**From:** Julia Davies [REDACTED]  
**Sent:** 05 November 2019 17:06  
**To:** Sarah Burrow <Sarah.Burrow@arun.gov.uk>  
**Cc:** Andrew Wood <Andrew.Wood@arun.gov.uk>; Planning.Responses <Planning.Responses@arun.gov.uk>  
**Subject:** Re: White Cottage (WA/22/19/PL)

As suggested, please find attached a revised copy of drawing B16f, with the soakaway reduced to 3 crates deep. I request that this drawing is uploaded to the planning portal and accepted as the agreed surface water design.

Drawing B16b August 2018 Scale 1:20 & 1:100 @ A1
Building Regulation Drawing - Externals Plan

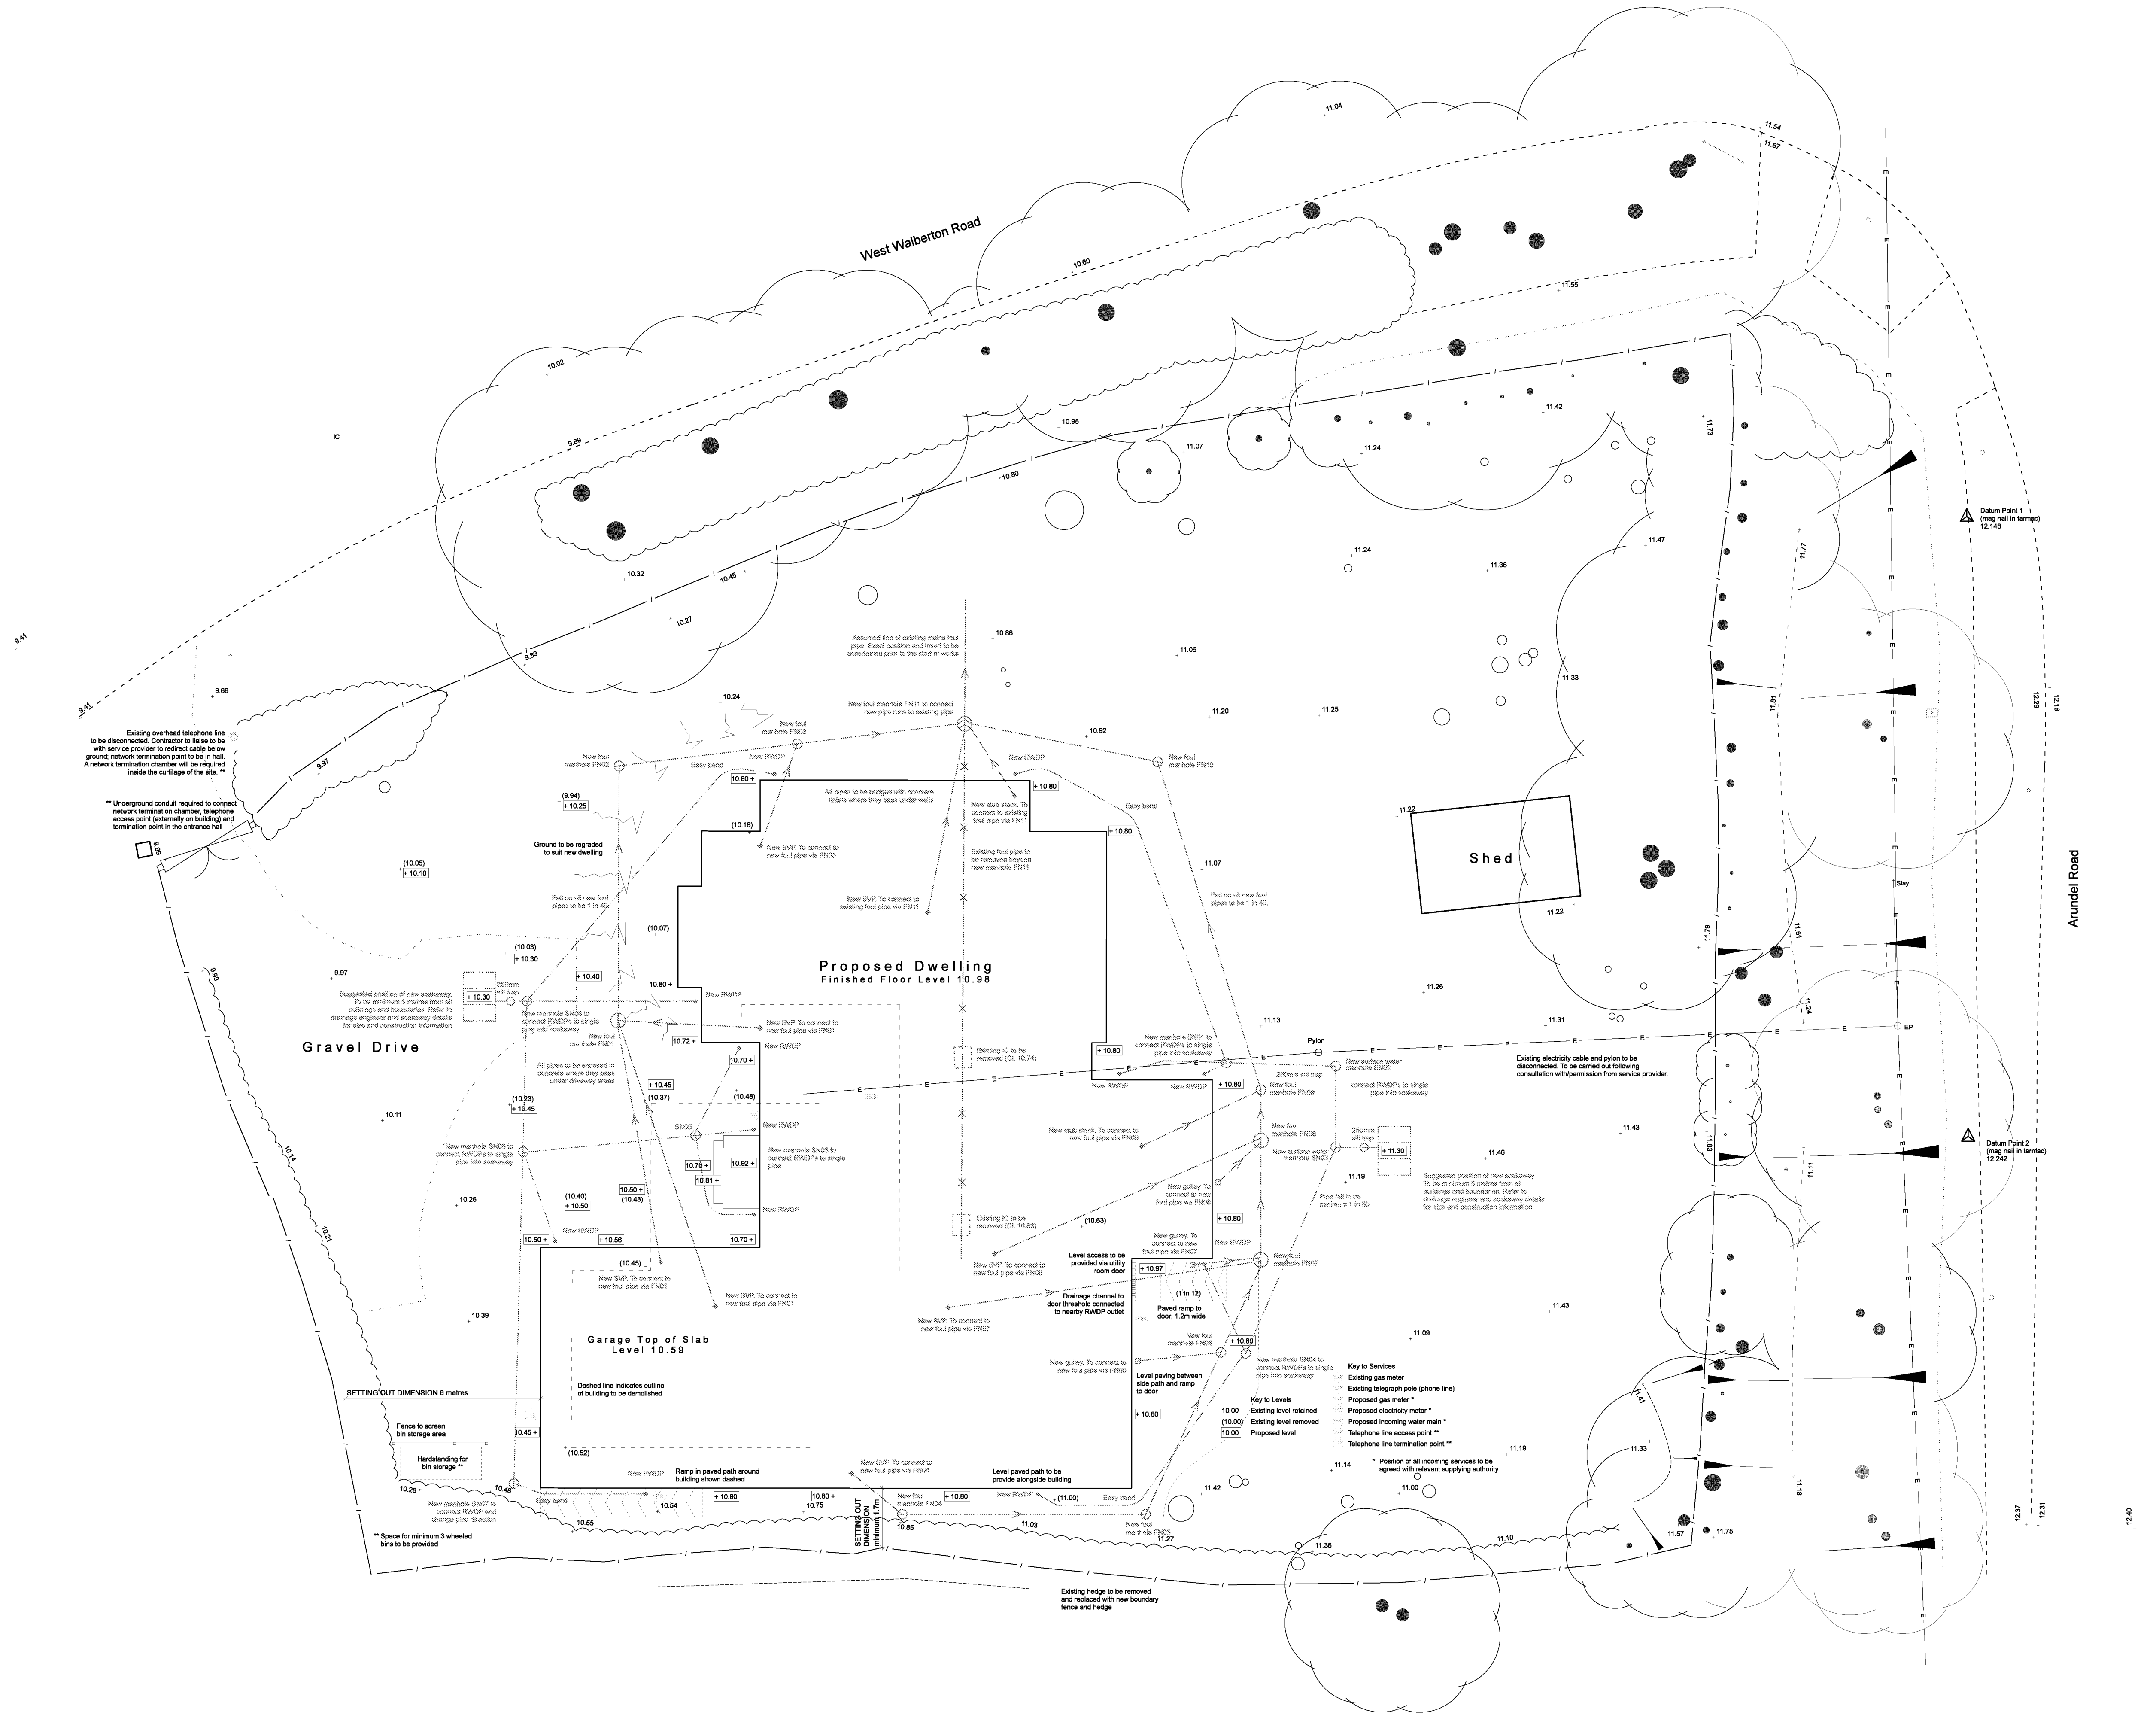
Thank you for the updated drawing. I appreciate that the extra level of crates have been included to compensate for the lower pipe level. However I am aware that this will provide a soakaway of capacity beyond design criteria which will result in additional expense to the applicant in excavation and materials. I am happy to accept this drawing and recommend removal of the condition, however if you supply a drawing with a soakaway of three crates depth I will also accept this. I asked simply that the pipe be raised to the highest point possible which I am happy that you have done.

An additional layer of crates has been added to the soakaways to ensure that the invert is at least 1.2 metres below the incoming pipe.

I have looked at raising the level of the incoming pipes; the length of the longest incoming pipe to the rear soakaway is around 20 metres. At a fall of 1 in 80 and with minimum 300mm cover over the pipe, it is not possible to raise the level of the pipe where it joins the soakaway.

Whilst the fall and pipe lengths for the front soakaway would allow the incoming pipe to be at a similar level to the rear soakaway pipes, a minimum 710mm cover is required over the crates as they are positioned below the driveway. Therefore the best I can do is to raise the pipe to connect to the top of the highest crate, as shown on the amended details attached.
